## Consultation Response from: KC Environmental Health (Pollution & Noise Control)

**2025/92161 - Land adj 17 Whitehall Road West, Birkenshaw, BD11 2LS**

**Discharge of details reserved by conditions 4-8 (intrusive investigations), 11 (Remediation Strategy and Verification Report ), 12 (CEMP), 13 (noise), 14 (Arboricultural Method Statement), 15 (CMP), 16 (highway), 17 (visibility), 18 (Safety Audit), 19 (estate streets), 20 (waste collection), 21 (surface water attenuation), 24 (bin storage), 25 (bicycle storage), 26 (drainage), 28 (drainage), 29 (CEMP: Biodiversity),-30 (landscape), 34 (solar panel array), 35 (materials), 38 (boundary treatments) on previous permission 2024/92281 for erection of 23 dwellings**

**Responding Date: 27th August 2025      Responding Officer: SR, MN**

Appendix 3: Monitoring Position

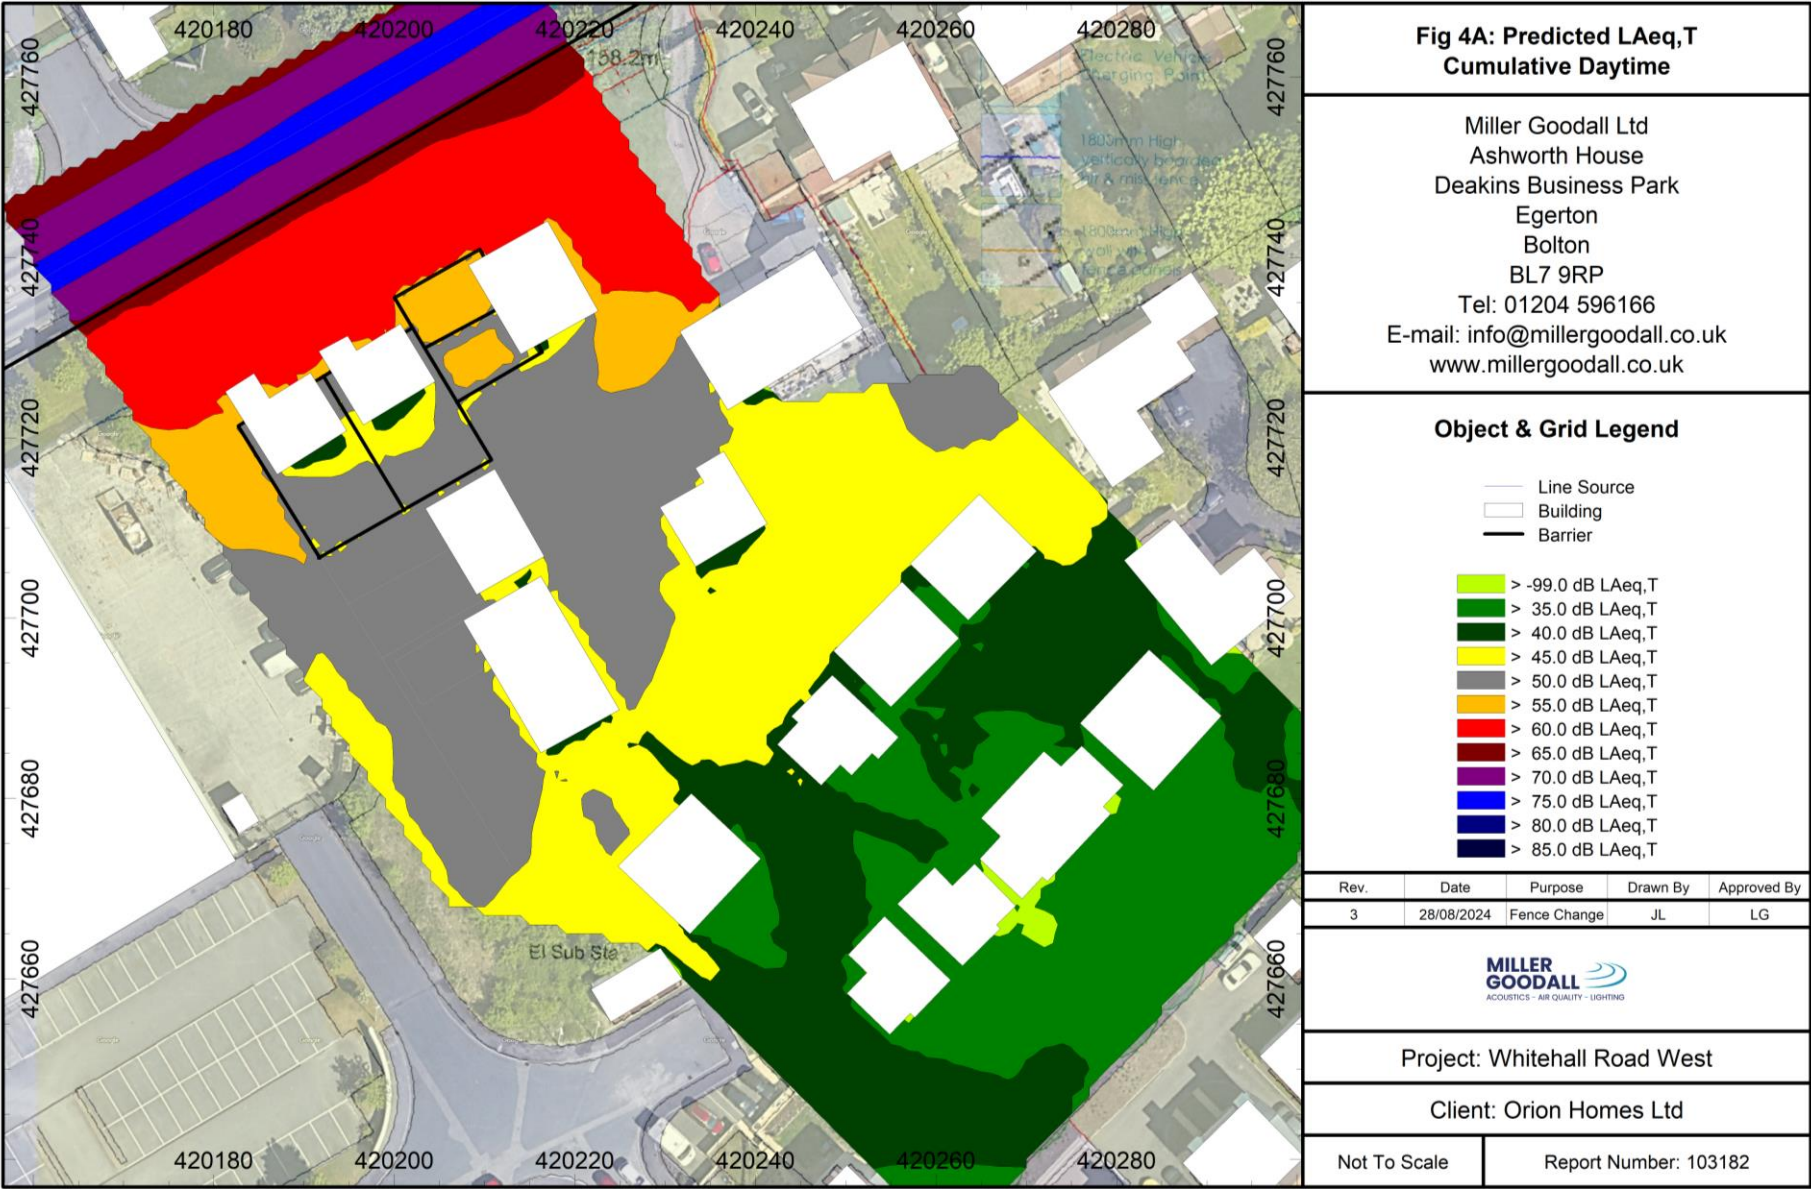
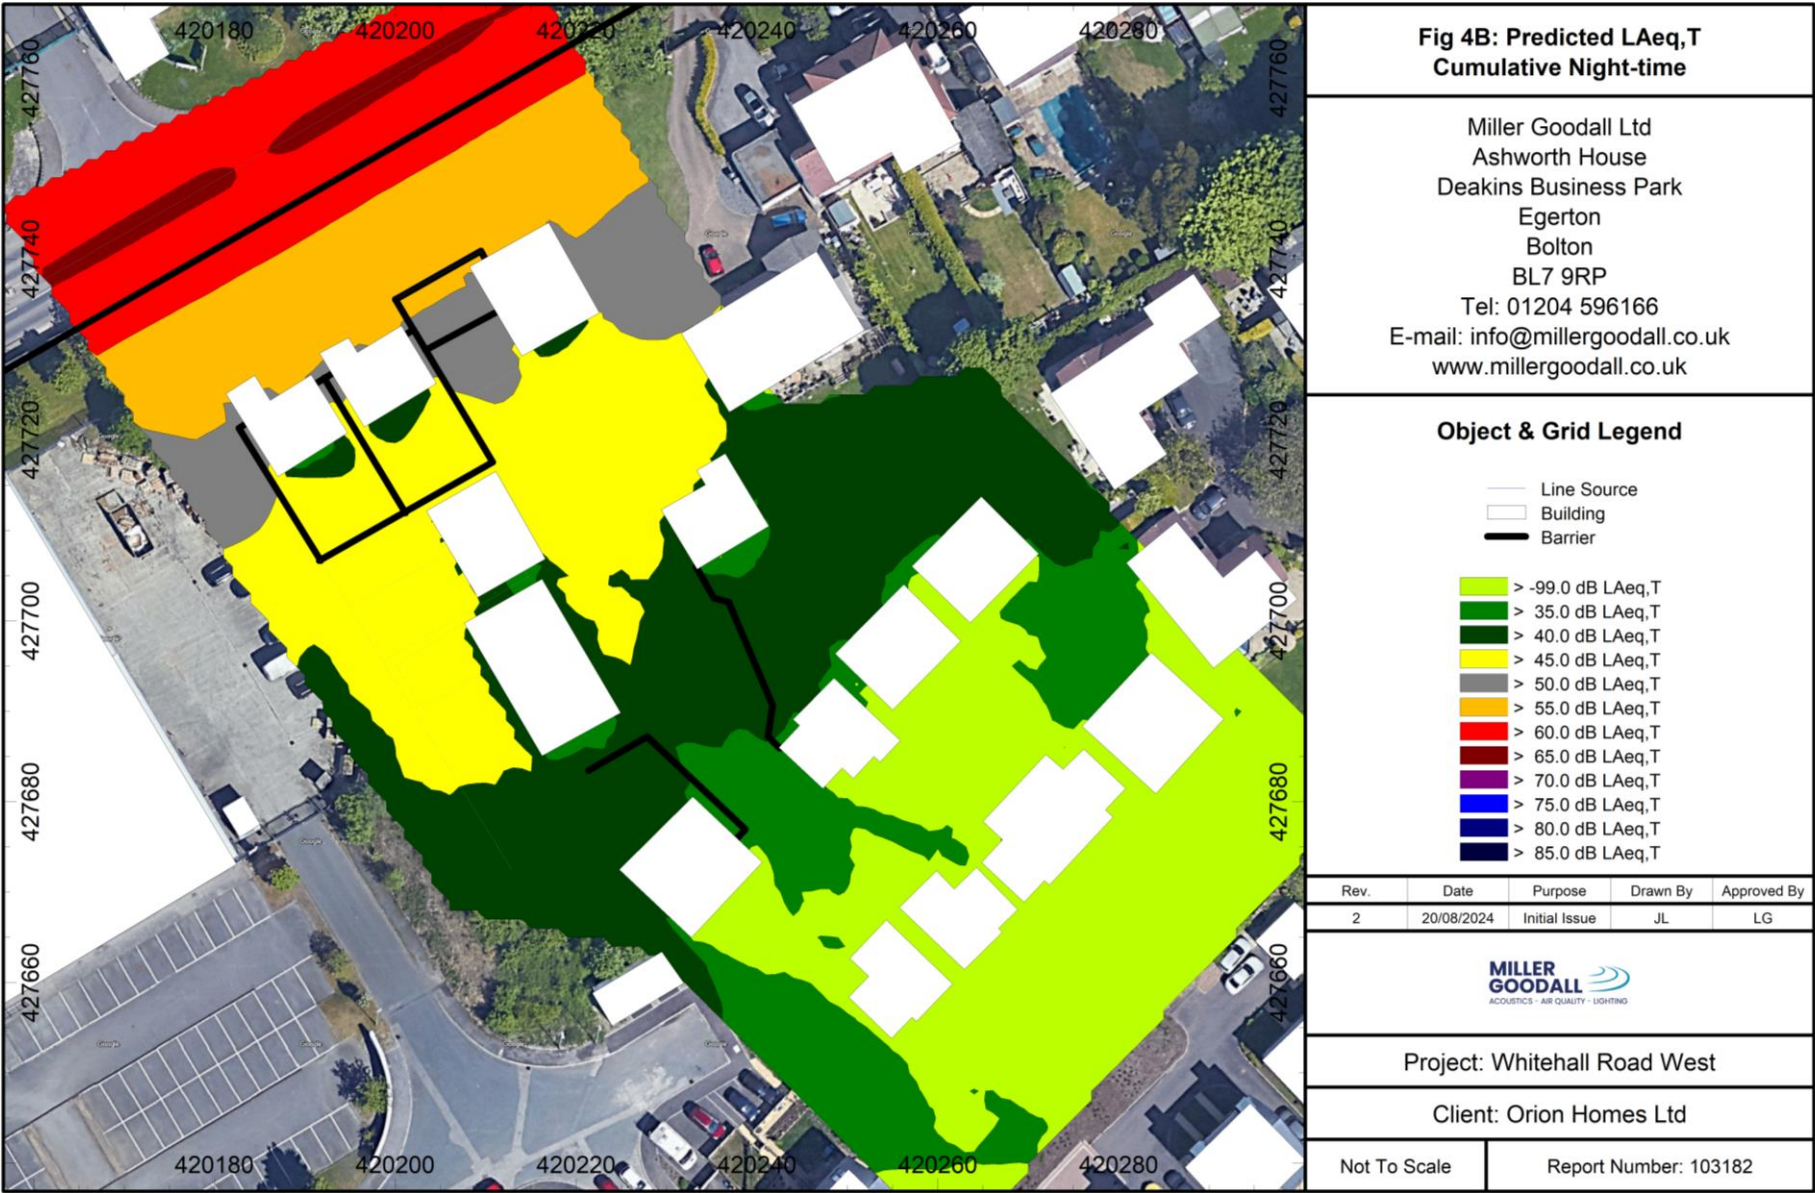
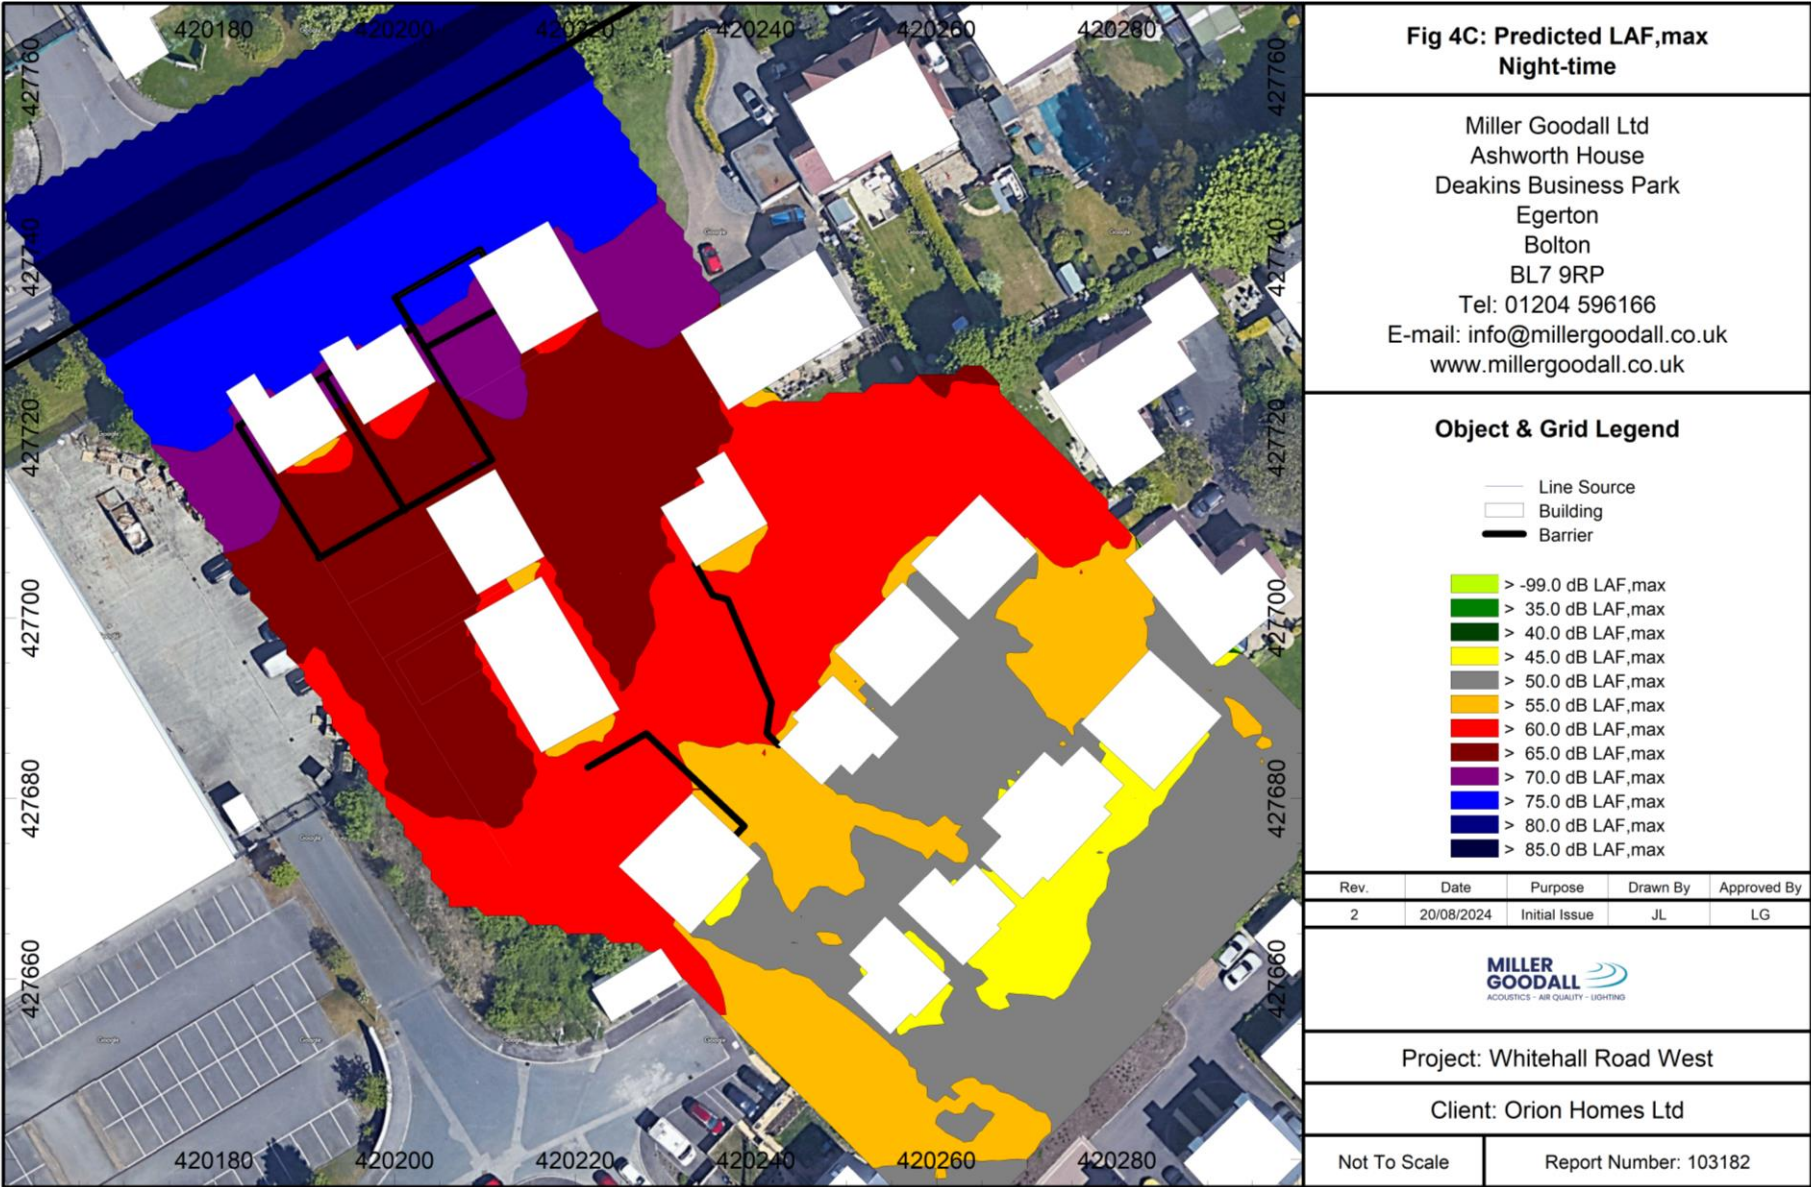
A background noise survey was undertaken between 1430hrs on 24 July 2024 through to 1030hrs on 26 July 2024 from a single monitoring position as shown in Appendix 3. and a summary of the findings is given in table 4. The dominant source would be from road traffic and comment is made in para 6.2 that that there was no noise evident from the substation to the south of the site and there was no activity witnessed on the minor roads. Any noise associated with the operation of the commercial unit has been recorded within the noise survey but was not distinct from other noise sources at the site.
